Submission Regarding SSD-77608714-Mod-2

Modification 2 to increase building height and other external modifications 1 Darling Point Road, Edgecliff

Dated: 26.05.2026

Extracts from the approved eastern elevation and proposed eastern elevation are provided below.

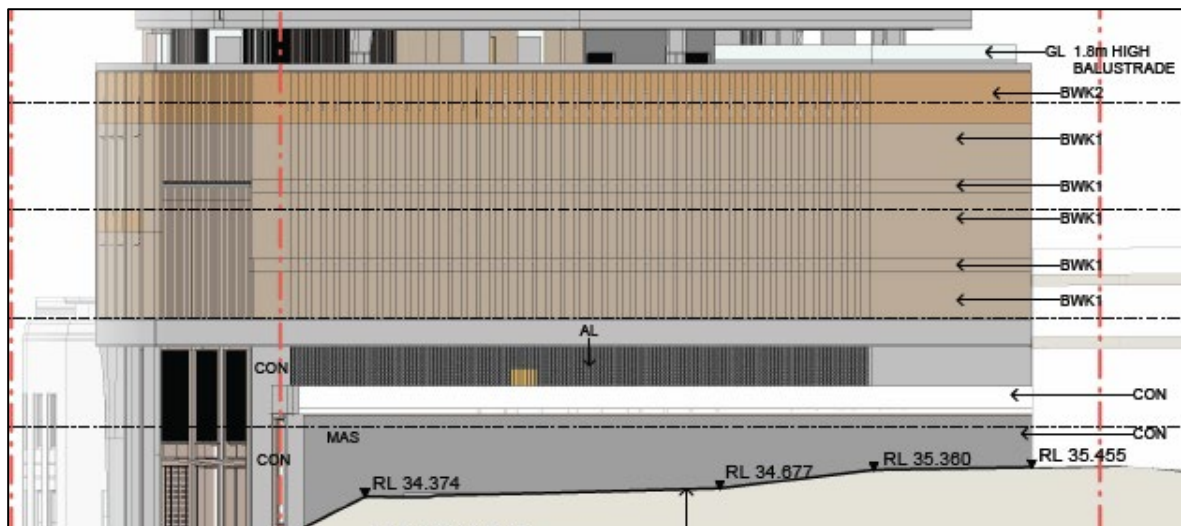
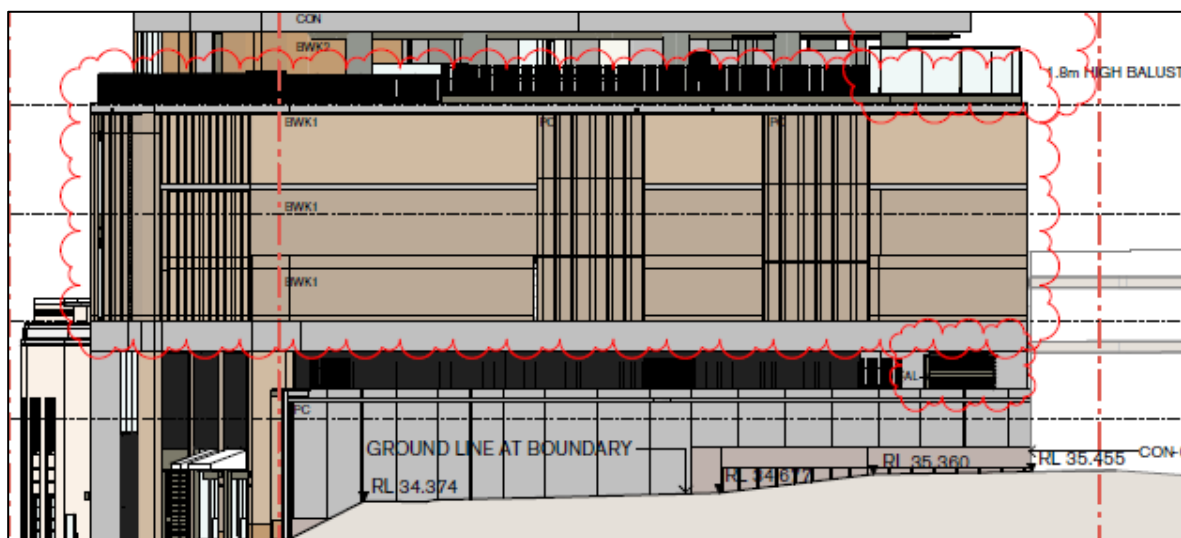
The proposed amendment introduces substantially wider gaps between the façade louvers, as indicated in the drawings submitted with the application.

Based on our assessment of the plans, the openings appear to be approximately 20–30 cm wide. Given the extremely close proximity of the structures - approximately 3 metres from our apartment windows - these openings will permit direct lines of sight from the adjoining car park area into our private living spaces, including:

This represents a serious and unacceptable invasion of privacy for residents of the adjoining building. The originally approved façade design provided appropriate visual screening and directional shielding. The proposed amendment materially weakens those protections.

The proposed openings will also allow unrestricted transmission of artificial light and noise from the car parking area directly toward our apartment.

The originally approved façade treatment appeared specifically designed to redirect light spill and vehicle noise laterally, thereby minimising impacts on neighbouring residents. The proposed amendment undermines that design intent by creating direct openings facing residential windows.

The widened louvre gaps create direct and unreasonable privacy impacts, compromise residential security, and materially reduce the amenity of adjoining apartments through increased noise and artificial light intrusion.

These impacts are avoidable. Eliminating the frontal gaps and fully redirecting the openings to the side, consistent with the intent of the originally approved design, would address the concerns raised above.

We therefore request that the proposed modification be refused unless the façade design is amended to eliminate direct openings toward adjoining residential apartments and restore adequate privacy and acoustic/light screening outcomes.
